November 27, 2017

RE: Homestead Suite - 5400 San Antonio Dr. NE
Grading and Drainage Plan
Engineer's Stamp Date 11/16/2017
Hydrology File: E18D050

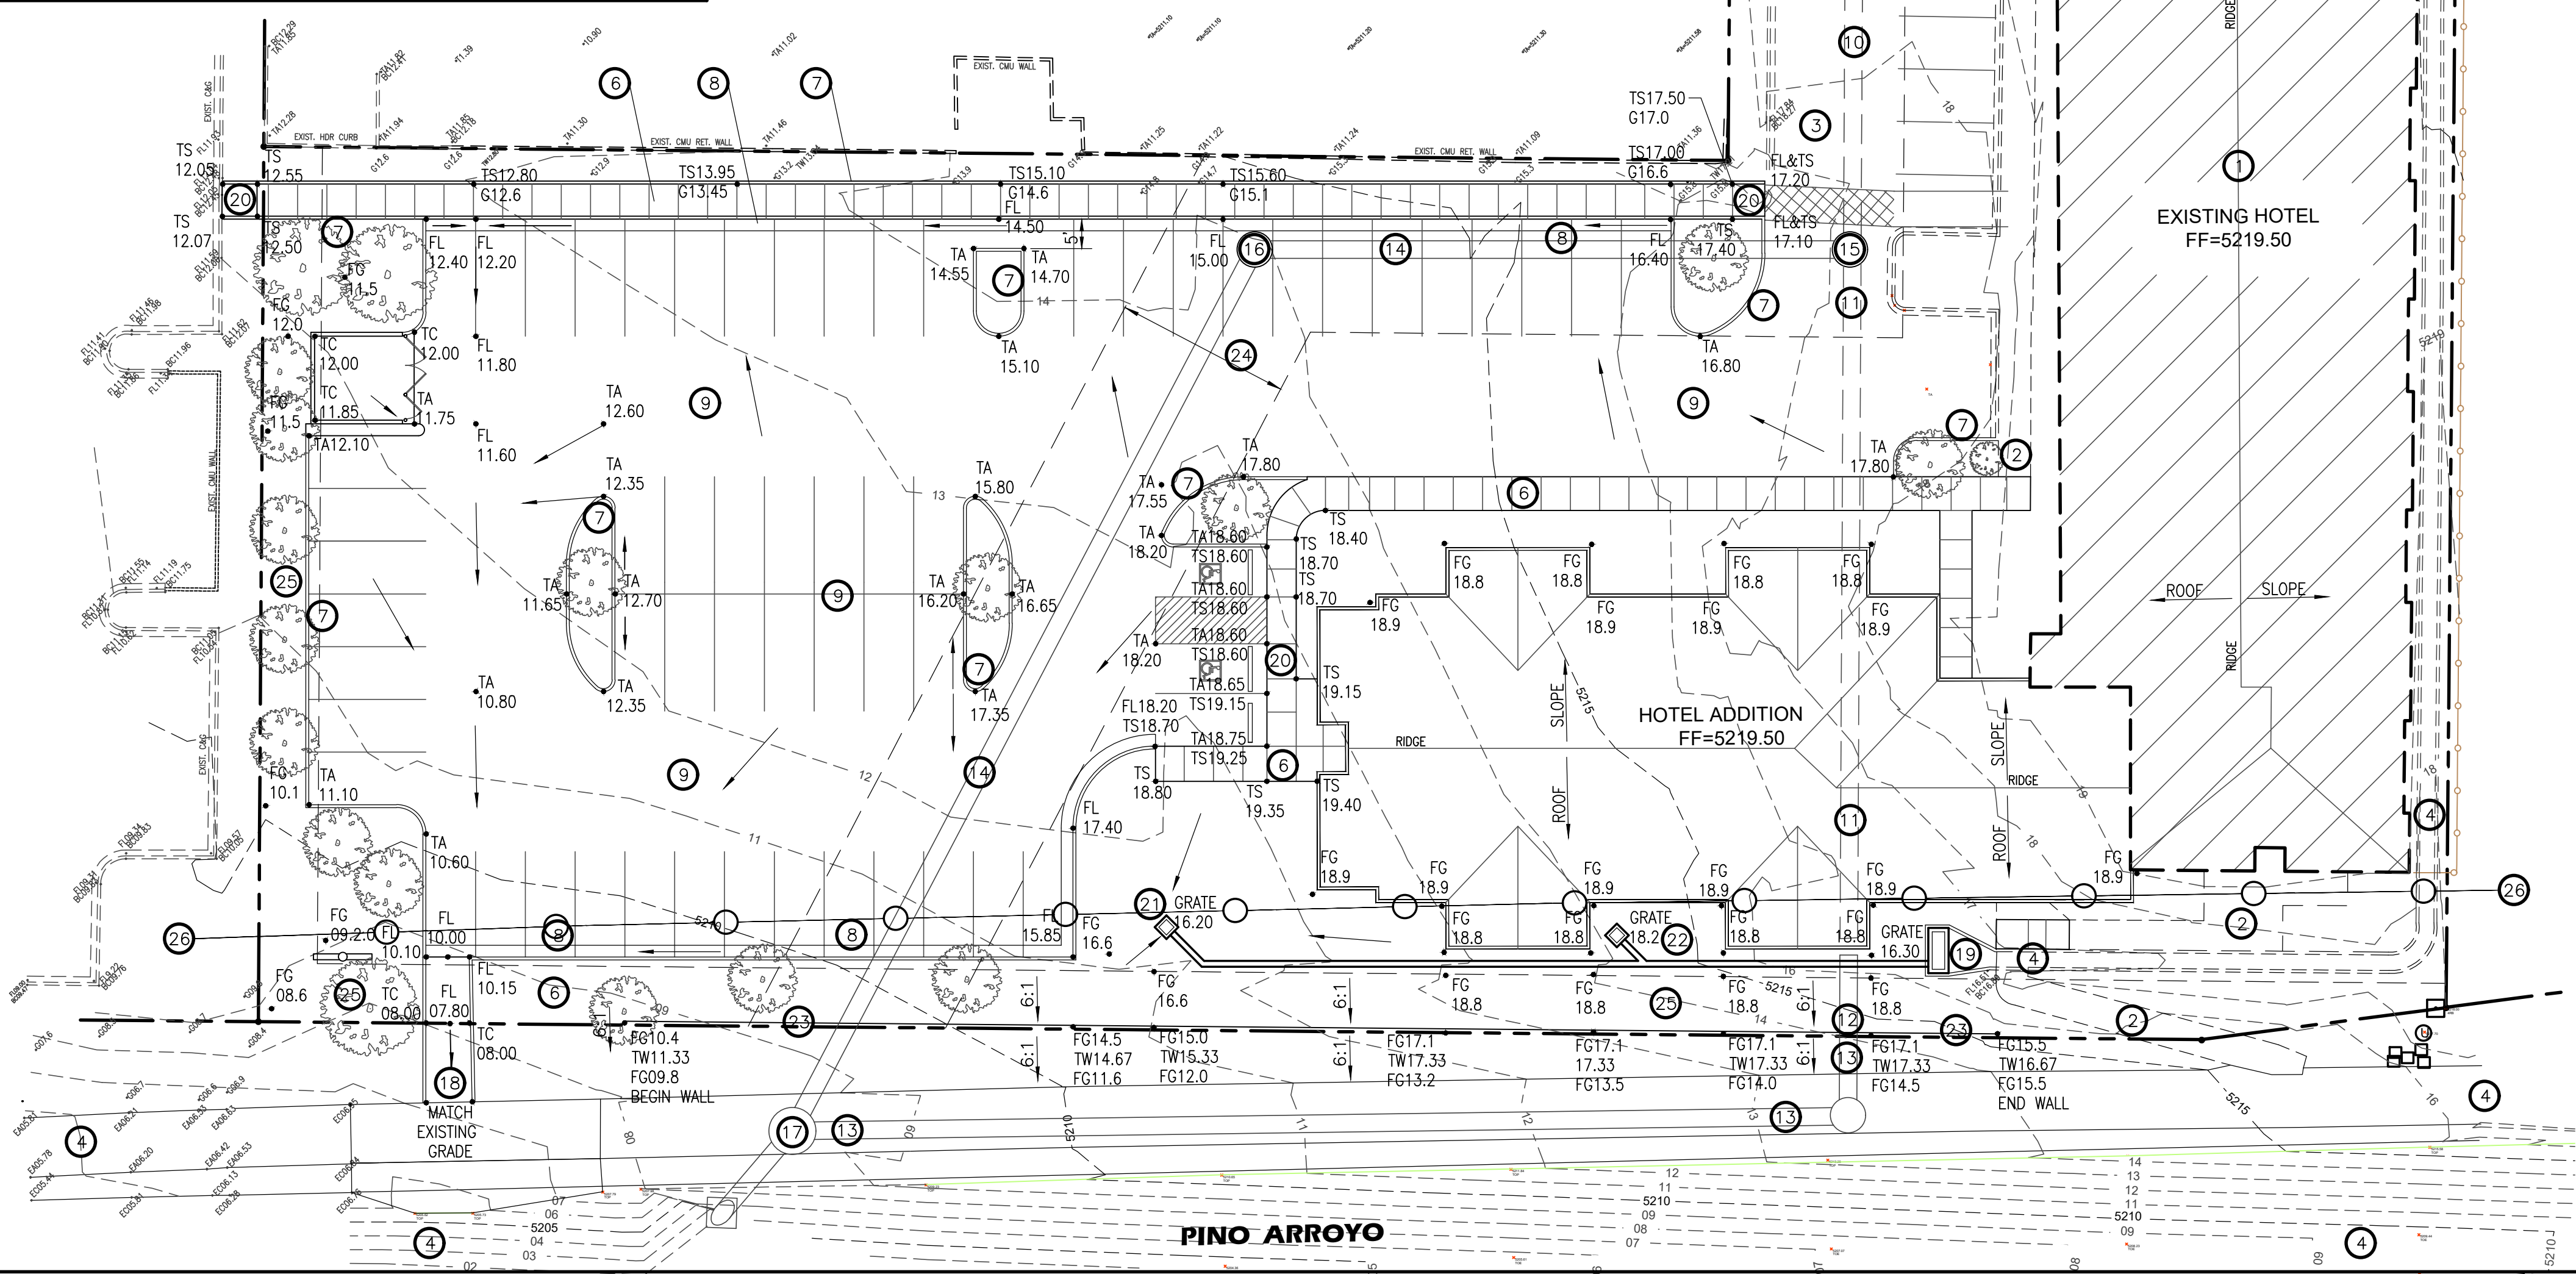
5. Keynote # 4 should say private instead of public, and Keynote # 17 needs to be labeled on the plan view.
6. Show the floodplain on the plan view and if any portion of the building is in the floodplain then an Elevation Certificate will be required for the building. The owner has the option to apply to FEMA for a LOMR or LOMR-F to relieve insurance requirements if any.

7. The Grading Notes and Erosion Control Notes are shown twice on the same sheet. Delete the redundant notes, and change note 4 in the Grading Notes from Bernalillo County to "City of Albuquerque Standard Specifications for Public Works Construction, 1986 Edition through update #9"
8. Identify the infrastructure that is to be constructed by City Work Order and include the channel Keynote #19. It should be Constructed in accordance with STD DWG 2260 and included in the Agreement and Covenant as privately maintained drainage improvements in a public Right of Way.
